**Re: Pueblo Viejo, No Address Provided, Traffic Circulation Layout
Architect's Stamp dated 06-05-12 (J13-D024)**

Based upon the information provided in your submittal received 06-05-12, the above referenced plan cannot be approved for Building Permit until the following comments are addressed:

REVISION DATE	
DATE	06-05-2012
SHEET NUMBER	C-1.0

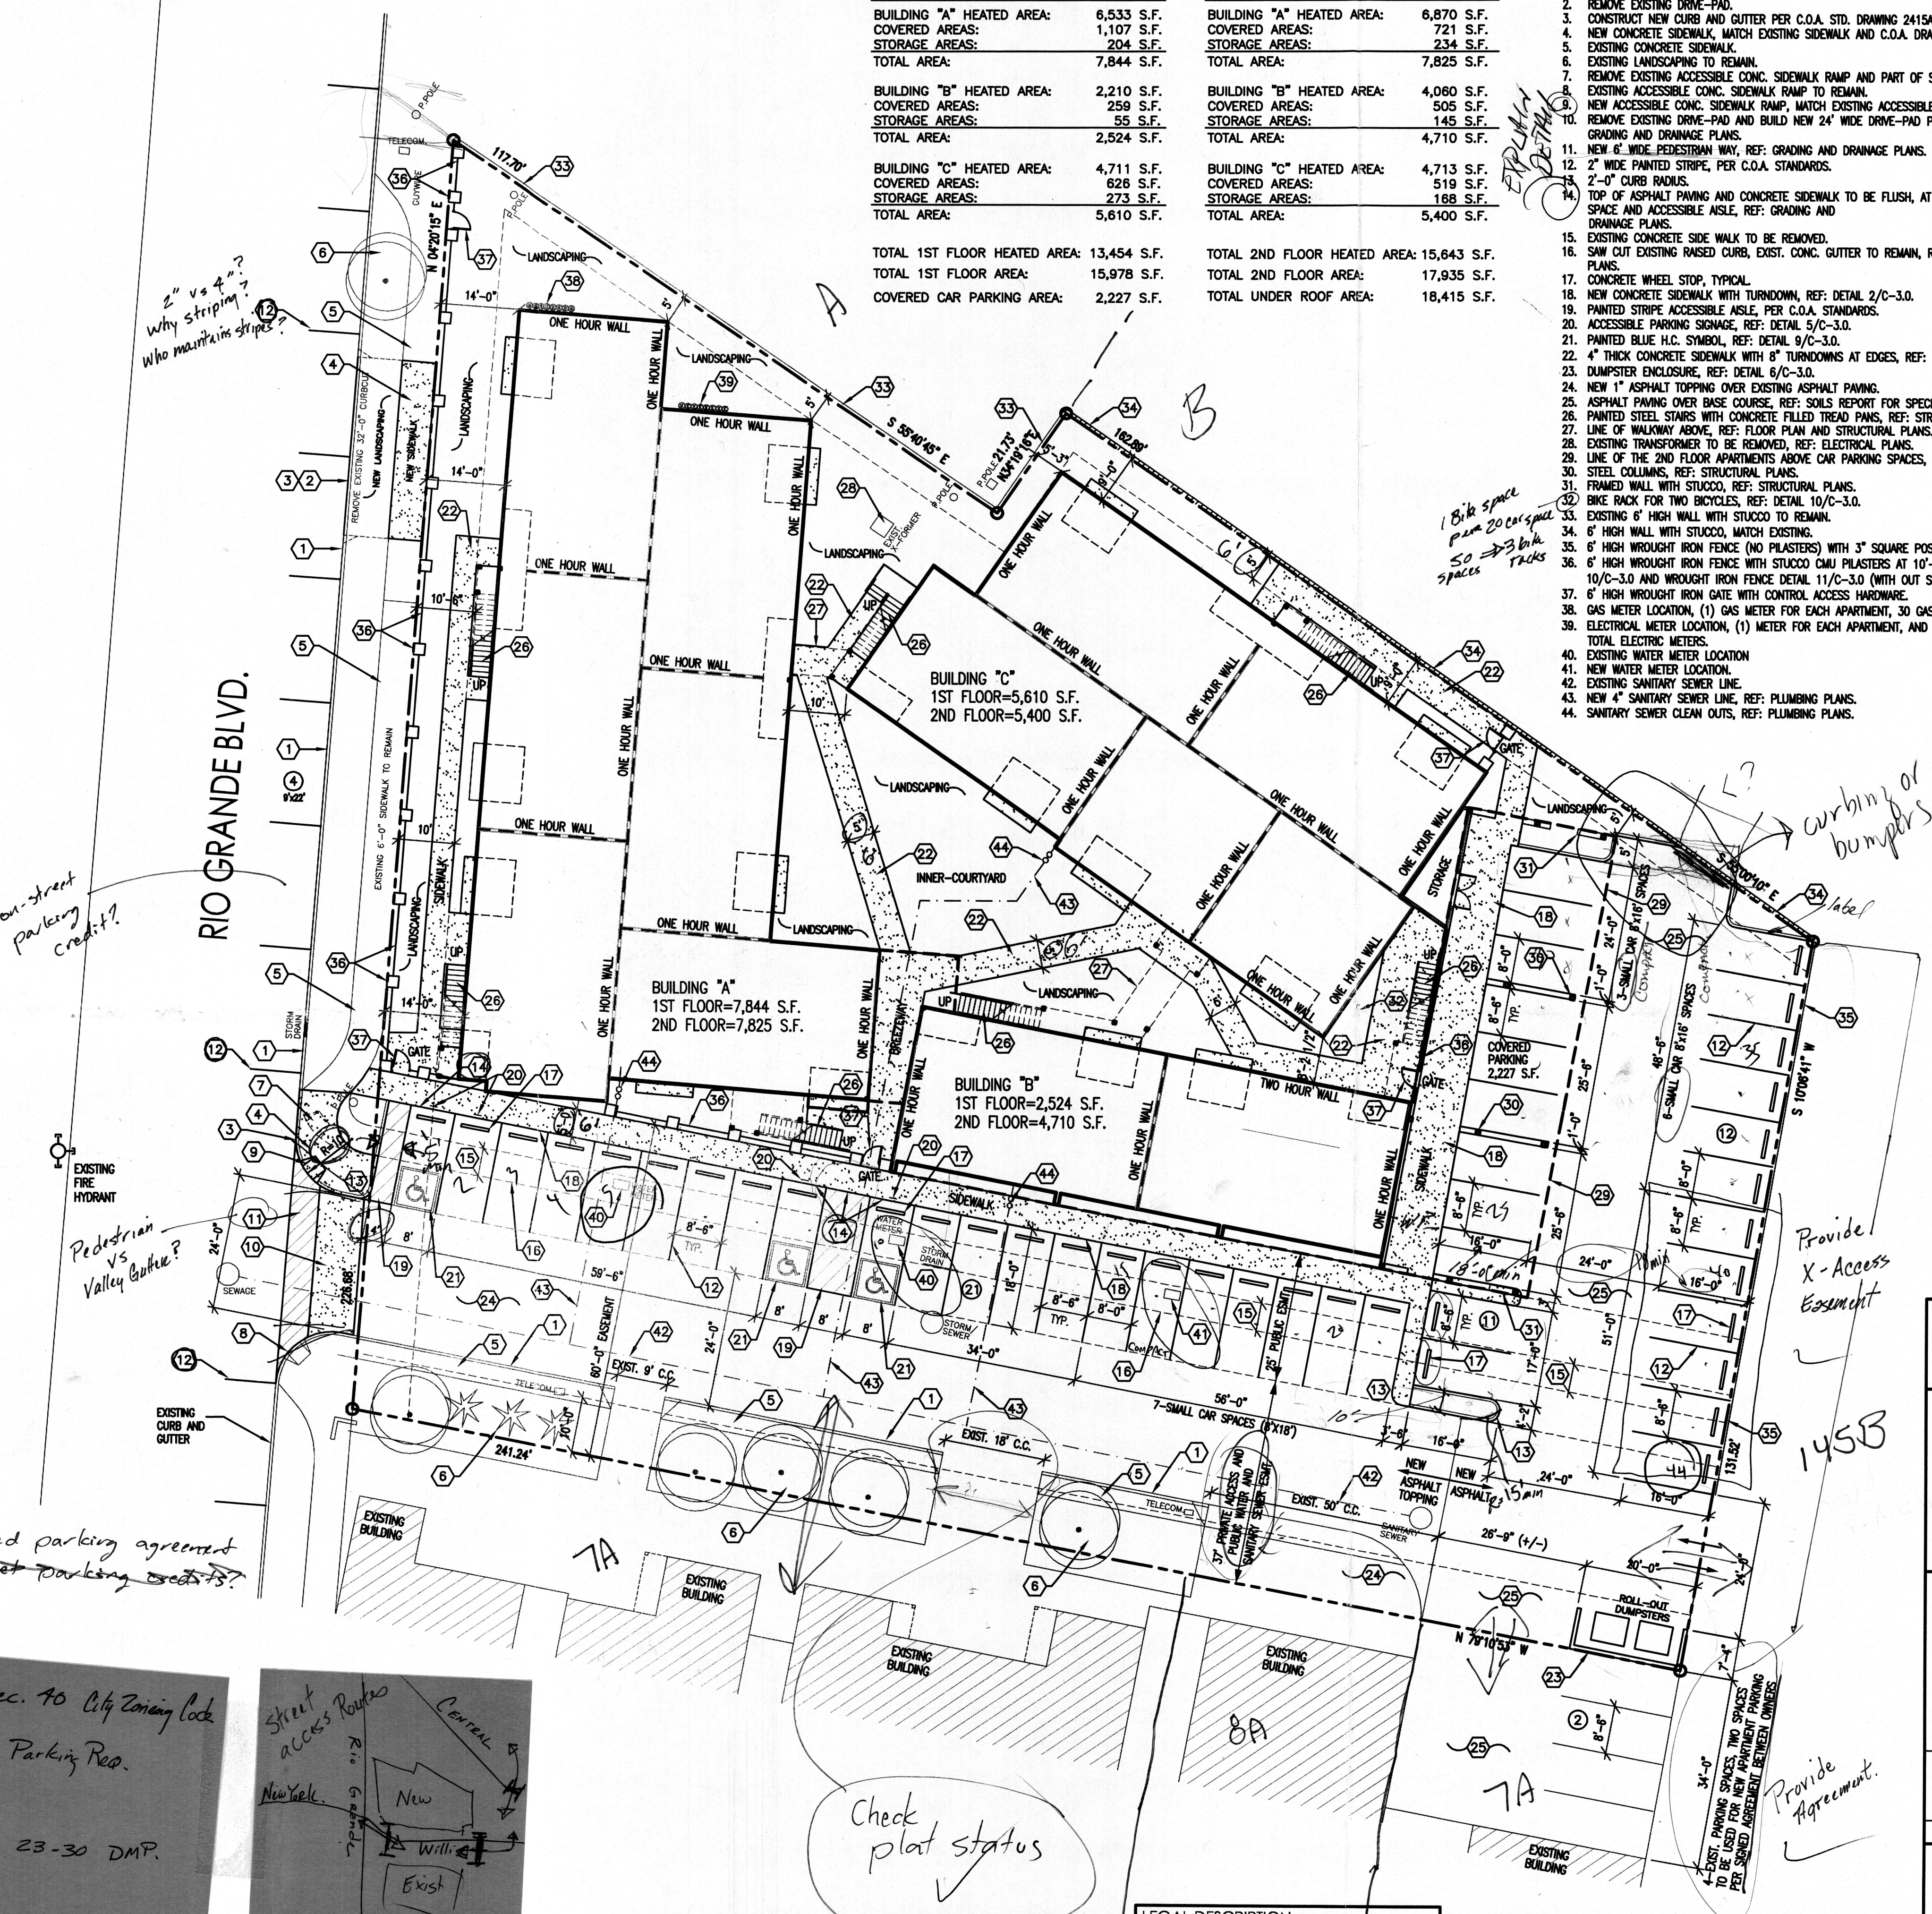
1. Records indicate that this portion of Willis Place SW (DRB Project Number 1007081) was approved to be vacated on July 27, 2011. However, there is no record of a platting action finalizing this vacation. Prior to any building permit approval, the final plat must be approved and recorded. Please provide a copy with the next submittal.

2. Clearly show all adjacent lot lines. Identify all adjacent lots.
3. Access easements are shown with Lots 7A, 7B, and 145B. These easements must be recorded, preferably with the platting action, prior to approval.

4. Clearly show how access will be shared with lot 145B. Does lot 145B access Central directly?
5. What is the address for the site?
6. This site was approved for 4 on-street parking credits on March 26, 2012. However, Transportation Development did not approve striping the parking stalls on the roadway. Please remove all on-street striping.

7. The parking calculations show shared parking with lot 7A. This requires a Shared Parking Agreement, signed by the City Attorney and the City Planning Director. Please refer to Appendix J of the *City of Albuquerque Zoning Code* for a sample agreement.

8. List radii for all curves shown; for passenger vehicles, the minimum end island radius is 15 feet.
9. Existing and proposed water meters are shown in the proposed parking stalls (see keyed notes 40 and 41). Are these meters traffic rated?

10. The handicapped spaces must include an 8-foot wide van access aisle; all other aisles should be 5 feet in width.

11. Label the compact parking spaces by placing the words "compact" on the pavement of each space.
12. A standard parking stall is 18 feet long, with a maximum 2-foot overhang. Overhang is not permitted across the property line.

13. Define width of all sidewalk, existing and proposed.
14. Keyed note 10 refers to City of Albuquerque Standard 2425; please revise to refer to City of Albuquerque Standard 2426.

15. Provide a legend, defining all linetypes and hatching.
16. Keyed note 11 defines a pedestrian way. However, this appears to be a valley gutter. Please remove proposed striping.

17. All sidewalks within the site must be 6 feet in width.
18. Clarify how vehicles will maneuver within the dead end parking aisle.
19. Per the *Development Process Manual*, Chapter 27, Section 2, Part B.1, only the following scales may be used:

- 1" = 50'
 - 1" = 40'
 - 1" = 20'
 - 1" = 10'
 - 1" = 100' (for overall layouts only)
